AJHajh-20220125-ArunCrem Planning Response_LPA.docx

Y/ 184/ 21/ DOC – CONDITIONS 8, 9 AND 10: DRAINAGE RESPONSE

Thank you for returning comments from your Drainage Engineer pertaining to planning conditions 8, 9 and 10 under planning permission Y/184/21/DOC for the Crematorium, Bognor.

Typical swale/basin gabion outfall detail

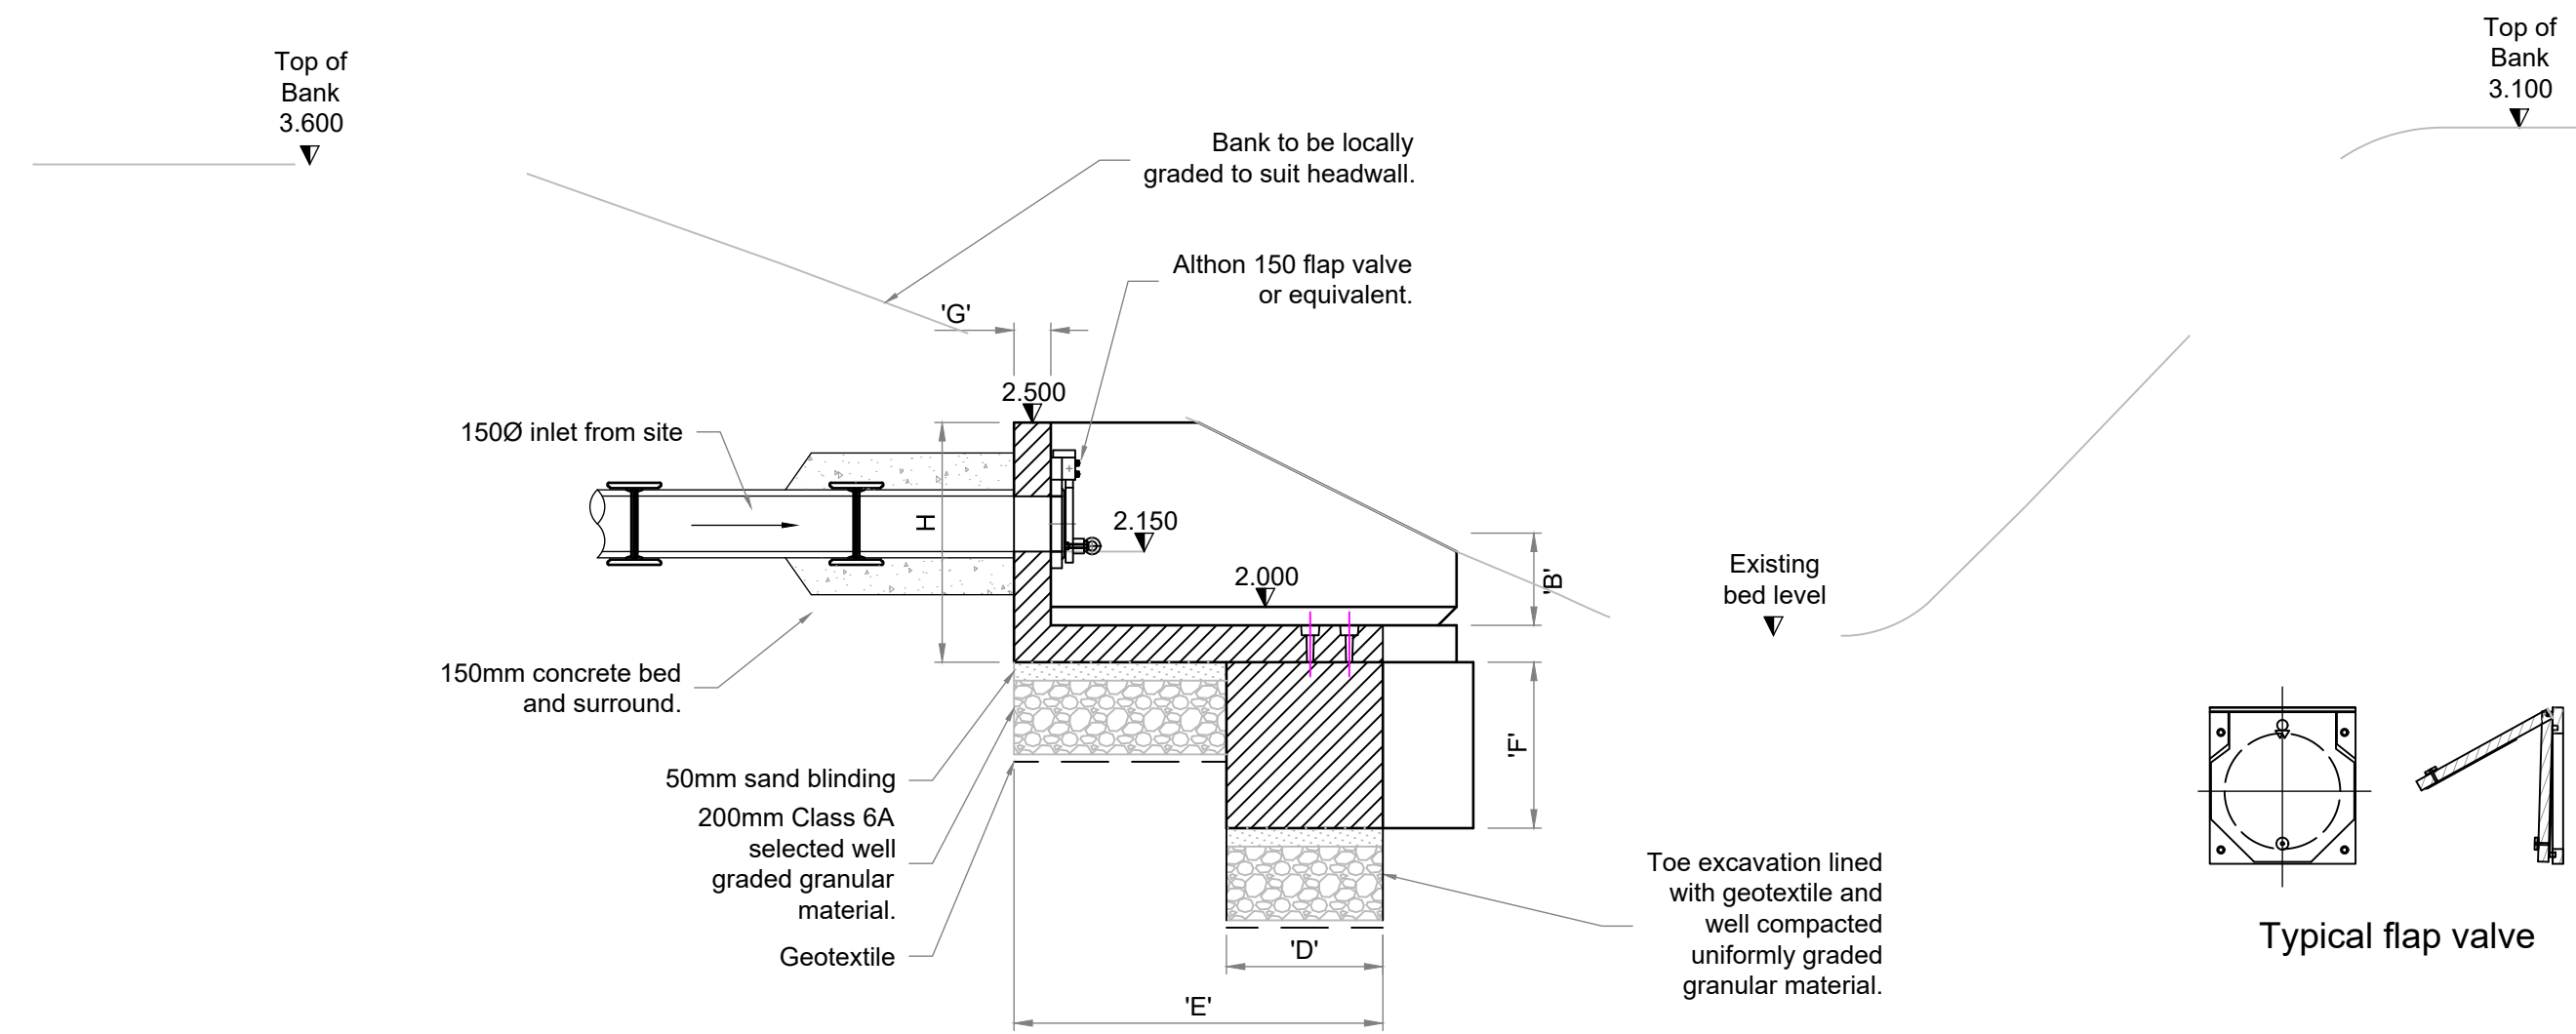
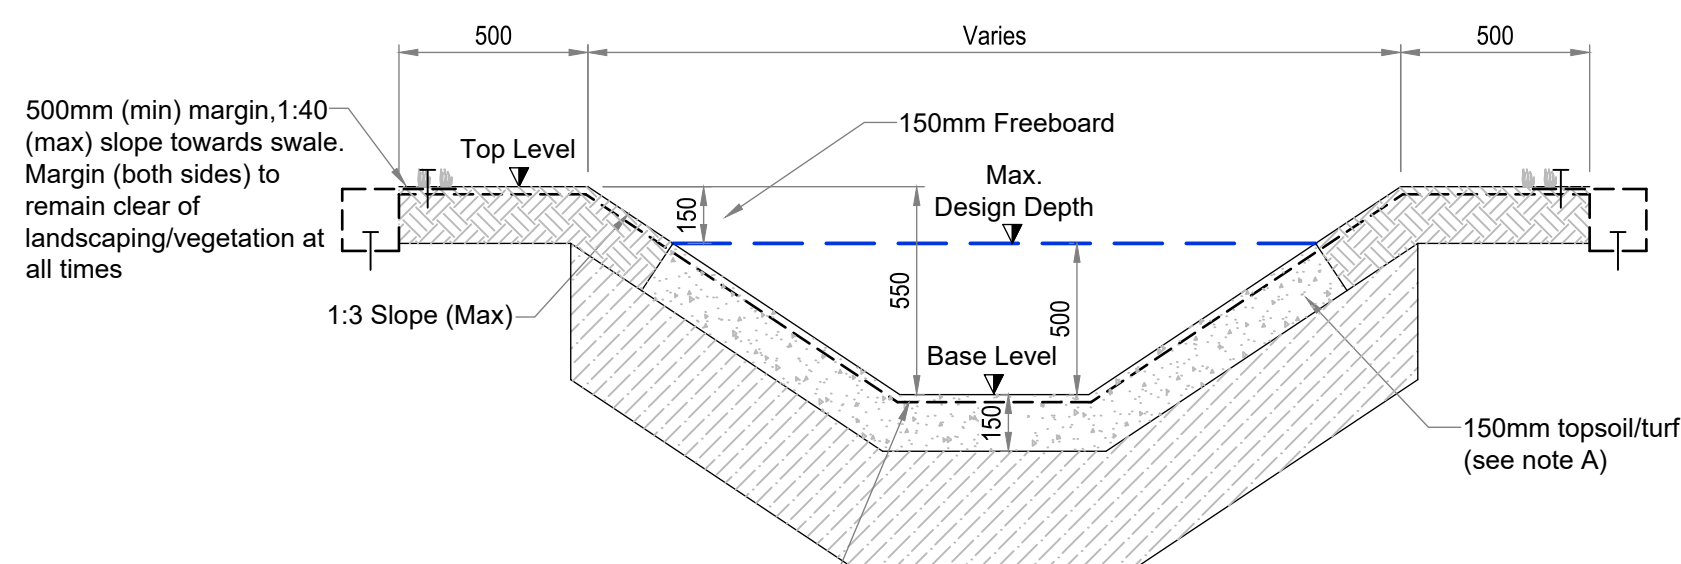
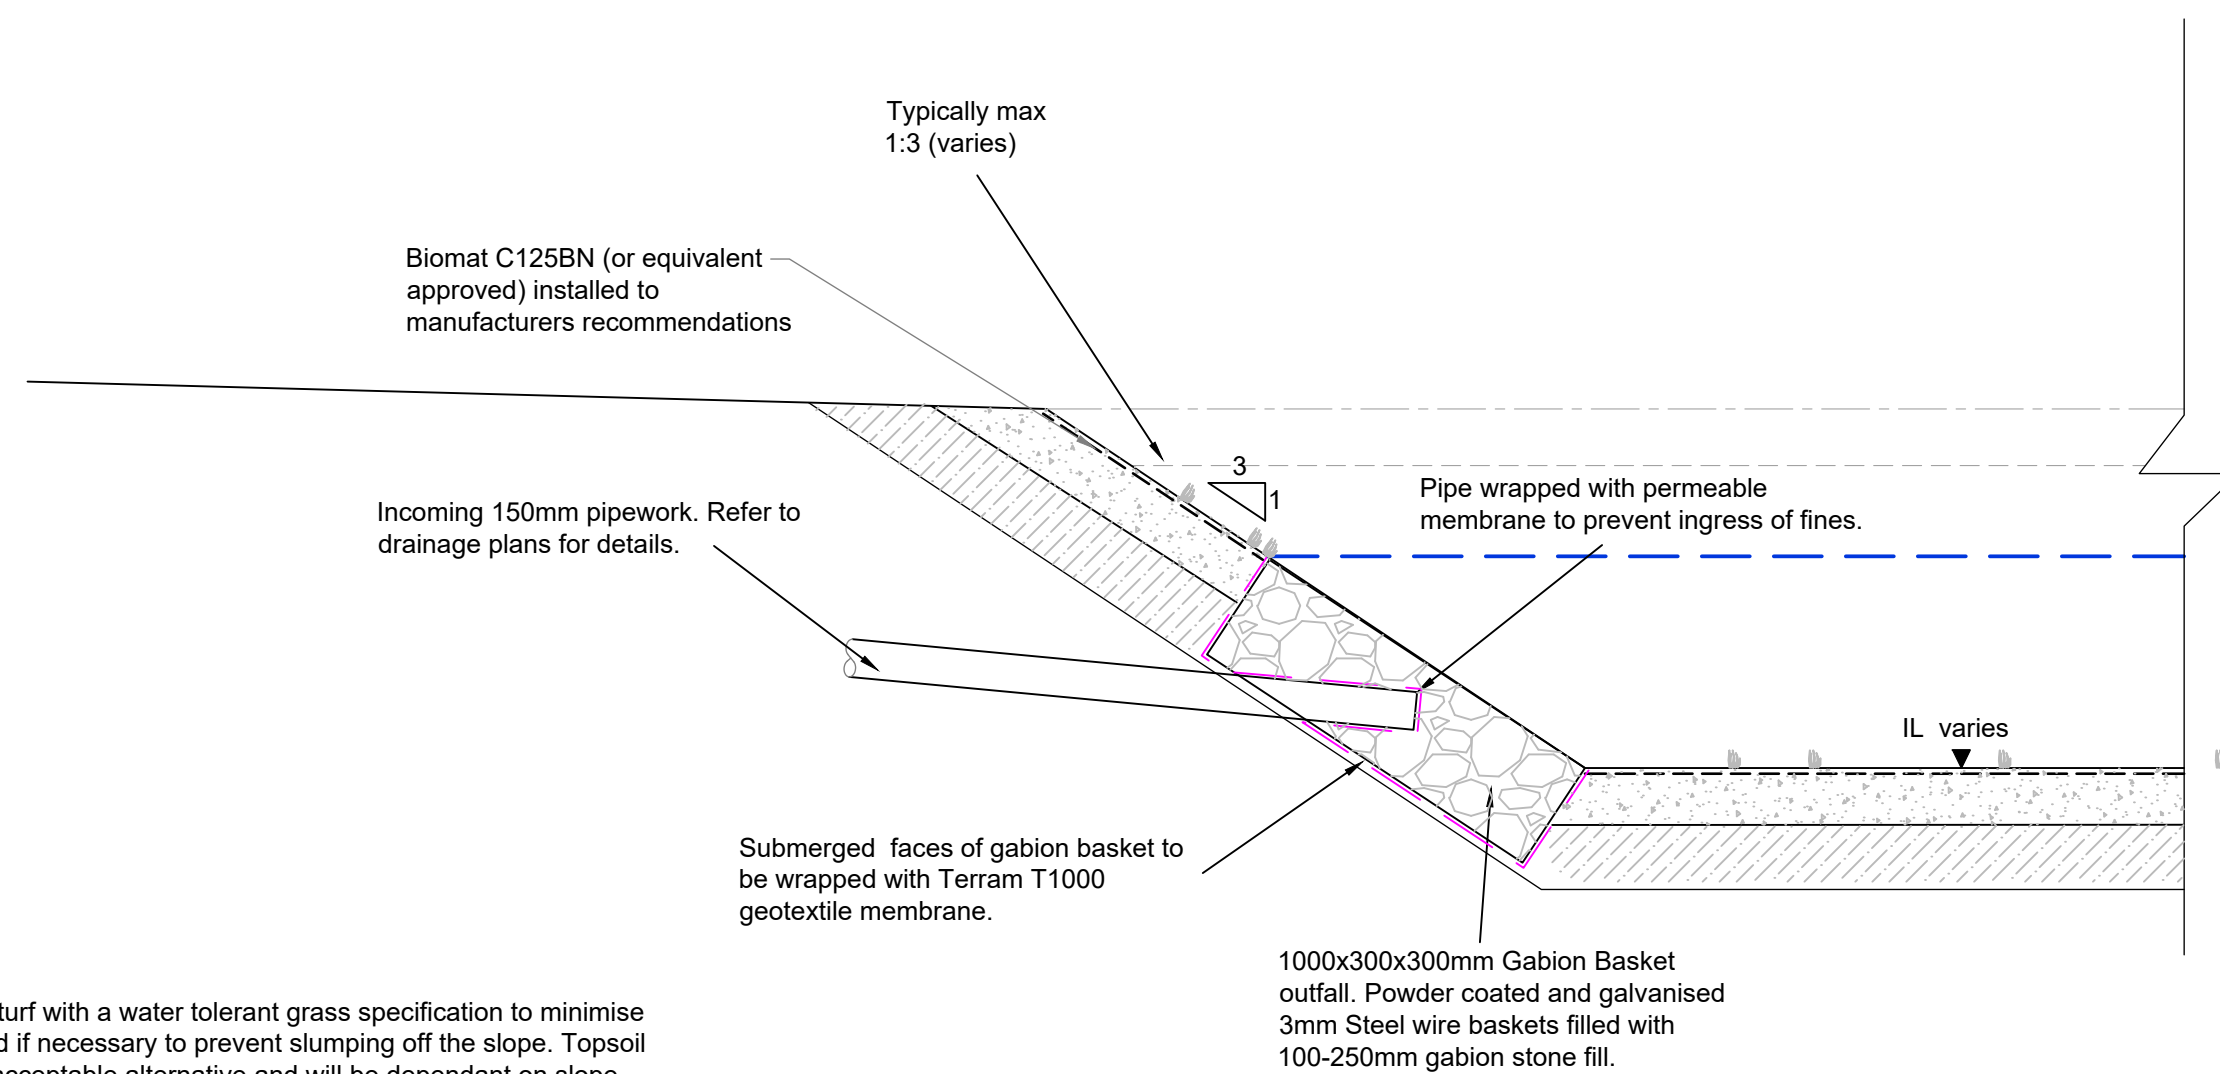
1. Please supply results of winter groundwater monitoring and winter infiltration testing.
2. Please supply calculations to support design.
3. Please supply an impermeable area catchment plan.
4. Please label all pipes with diameter and fall.
5. Hydrobrake unit references should be included on layout plans.
6. Please label finish and formation level of permeable paving.
7. Gullies and channel drains should be labelled with cover levels.
8. The gabion outfall construction detail drawing is unclear. Is it proposed to have buried pipes discharging to the basin?

8. The gabion basket is to be built into the embankment and to be exposed so as to be accessible for maintenance. The pipework will be within the basket and wrapped in a permeable membrane to prevent build-up of fines. The gabion provides siltation protection as well as dispersal of incoming flow to reduce scour. The gabion basket also removes the need for a traditional headwall and grille, reduces the maintenance requirements and provides a bigger area of contact/surface flow.
